**Consultation Response from KC,  
 Conservation and Design**
**2021/92086 land at, Bradley Villa Farm, Bradley Road, Bradley, Huddersfield, HD2 2JX**
**Erection of 270 residential dwellings and associated infrastructure and access**
**Date Responded: 09.07.21    Responding Officer: NG    Responding Ref: HS11 / HUD 11/237**
**Premature development proposal.**

Illustrative masterplan 2021

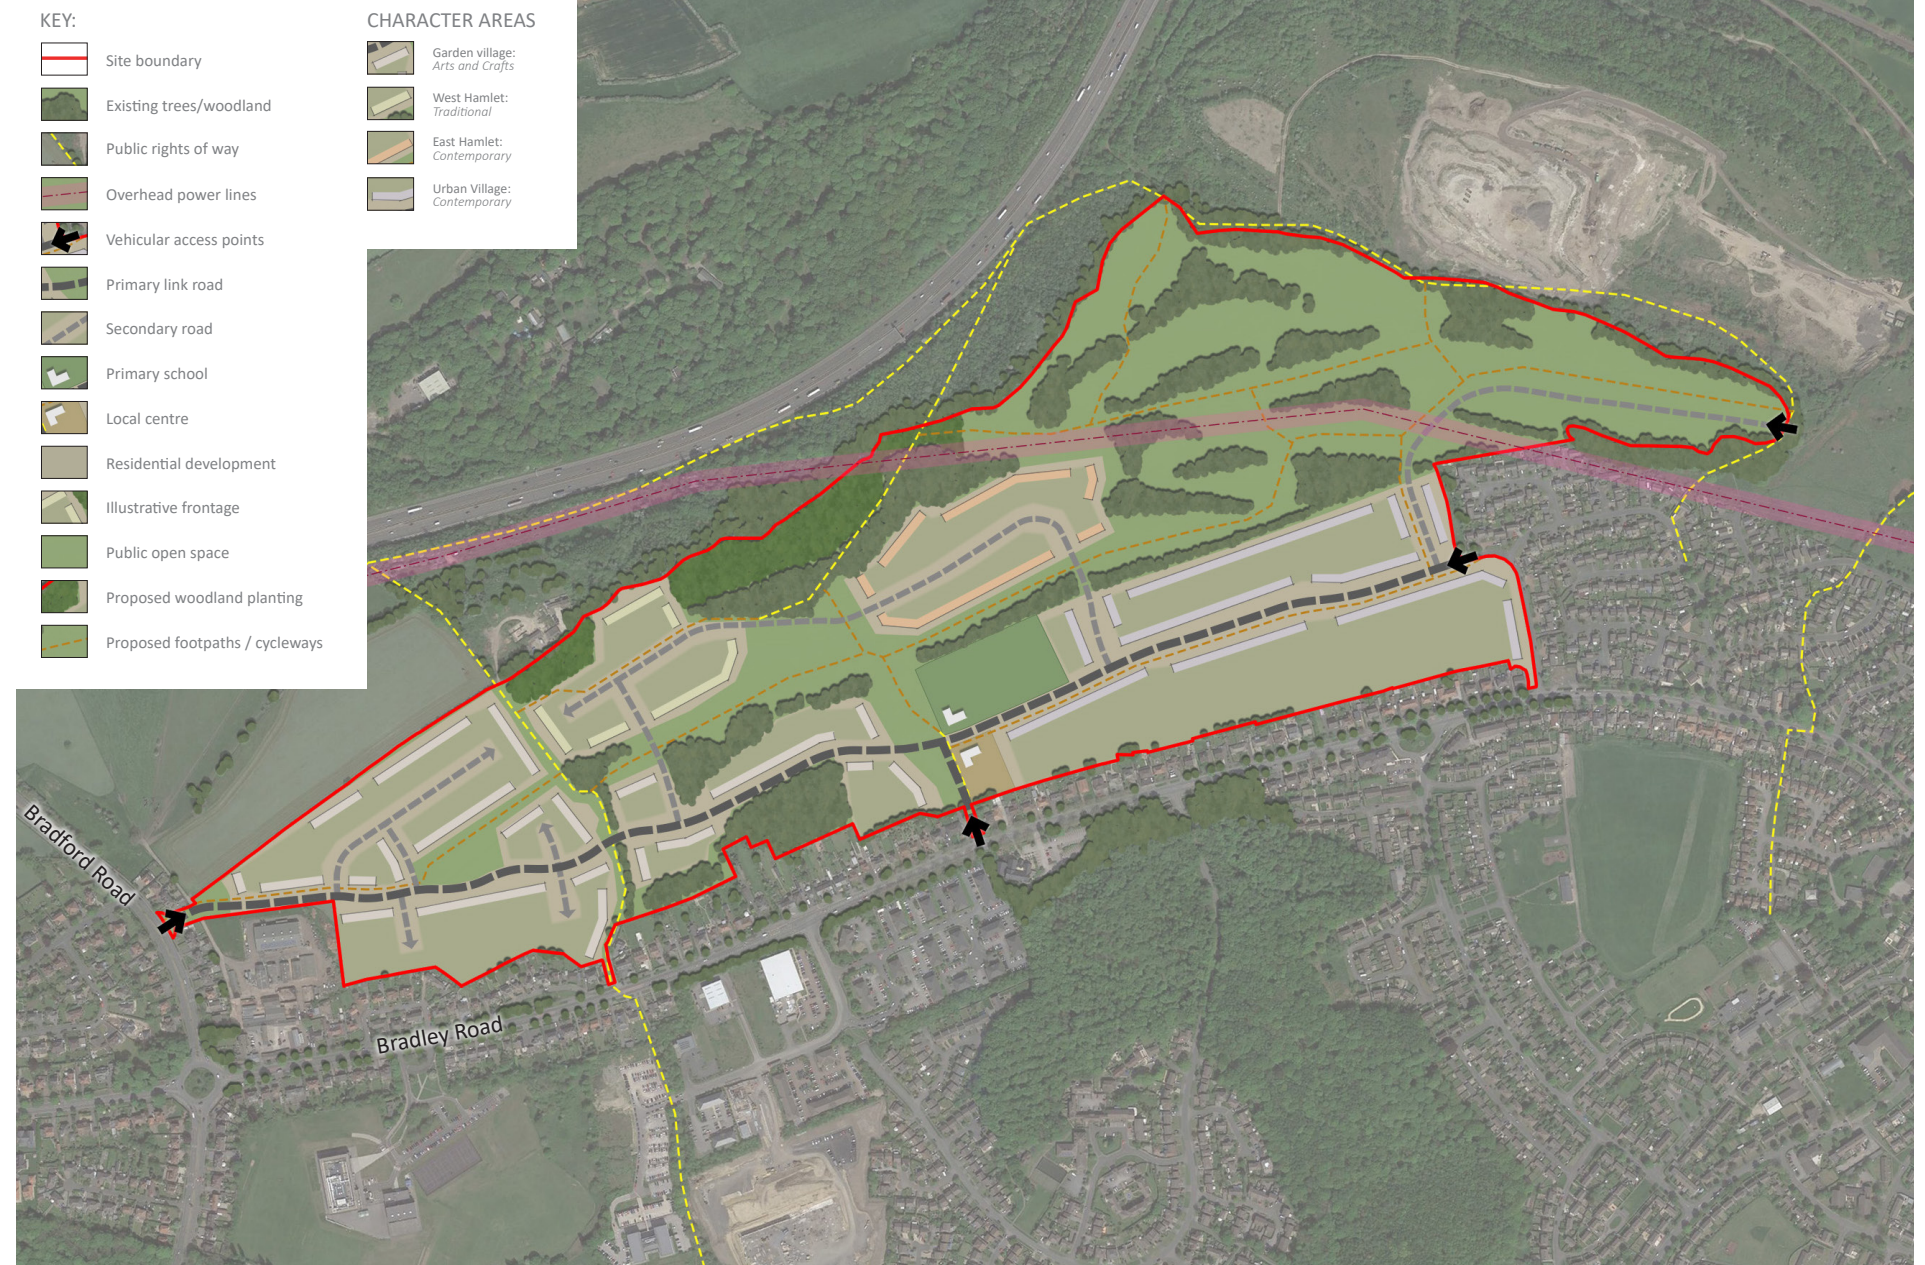
The proposed site layout plan (Drg. No. BVF-16-02-3) appears to exclude Shepherd’s Thorne Lane from the development site altogether, other than clearing the established hedgerows on the western side of the lane, to accommodate boundary walls, fencing and hardstanding for the Redrow residential units which abut the lane. The result would be to transform the character of the historic lane into a narrowly enclosed corridor which would again be poorly integrated into the Redrow housing layout and fail to enhance the use of the lane as a potential recreational route, (linking the site into the wider countryside and extending across the motorway). As key north-south access across the site the relationship to the edge of the Redrow development with the historic lane should be reviewed to create a more positive relationship with the historic route, enhancing its permeability and reflecting its historic character.

The current disconnection with the indicative eastern area of the HS11 allocation site means that the proposed spinal road in the Redrow site comes to a dead end at Shepherd’s Thorne Lane. This has the potential to be a significant junction linking the cross site vehicular route to the recreational route and consequently requires detailed consideration to create a landmark node defined by its space and appropriate planting. The current Redrow scheme should be reviewed to enhance this node and achieve its potential as a local landmark.

- **Hard surface and frontage parking.** Parts of the streetscape on the Redrow Layout would be dominated by hard standing and frontage parking, with the terraced units having no clear access for storage space (e.g. units 35-38 and 108 – 111). These units which would have a disproportionately negative impact on the streetscape and negate the potential for coherent street-tree planting. The layout and design approach to the frontage should be reconsidered to better indicate the smaller units and enhance the green space and tree planting connections.
